Subdivision Comments

From: Jesse Cox, Environmental Health Supervisor
Holly Erdman, Environmental Health Specialist

RE: LPF-21-00009 Akehurst

AKEHURST PLAT
 A PORTION OF THE NW 1/4 OF SECTION 20, TOWNSHIP 18 NORTH, RANGE 19 EAST, W.M.,
 KITTITAS COUNTY, WASHINGTON

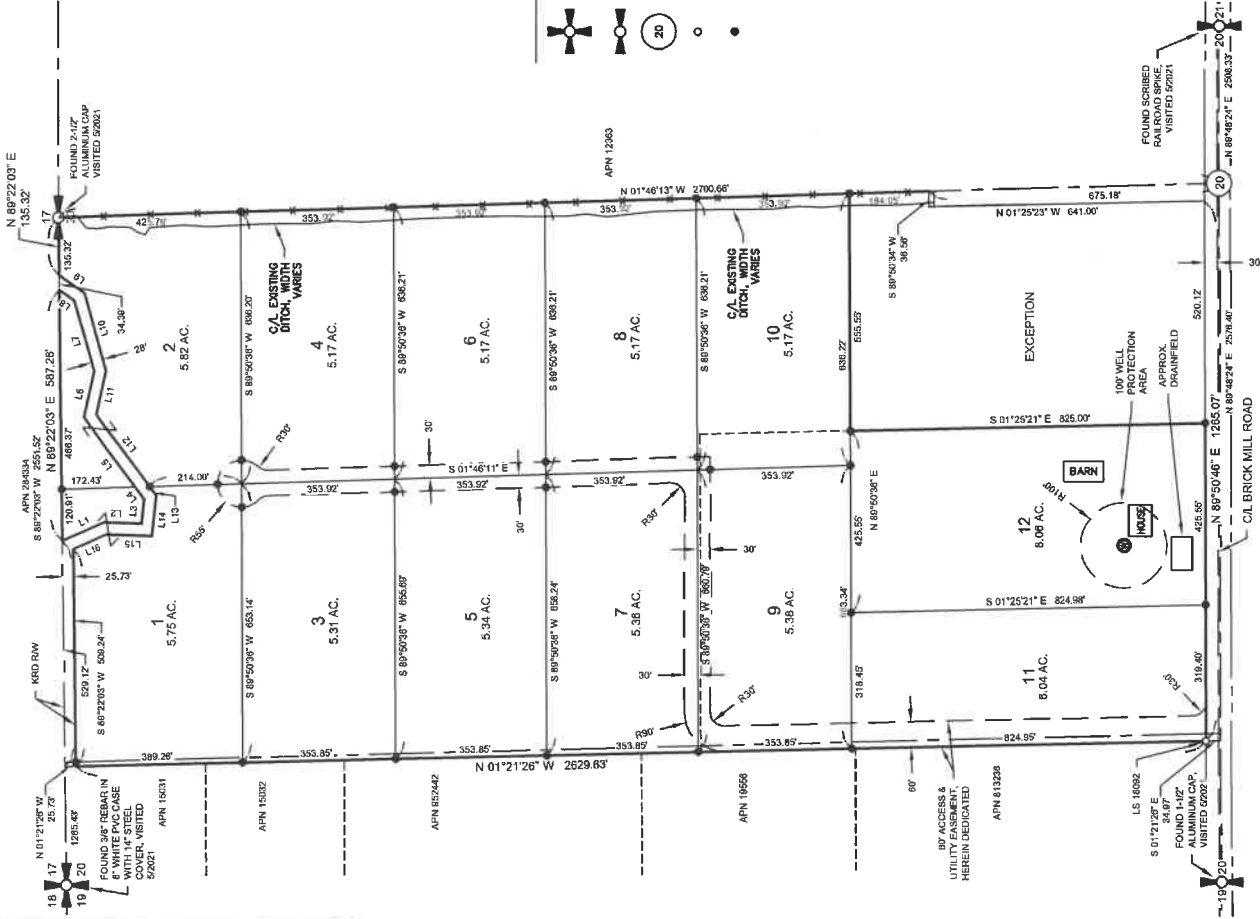
The proposed long plat indicates individual wells will be used. All wells must meet setbacks required in Kittitas County Code prior to final approval.

The proposed long plat indicates individual wells will be utilized. In accordance with KCC 13.35.020, individual wells will need to be drilled and adequate water rights or a certificate of water budget neutrality provided for each new lot proposed.
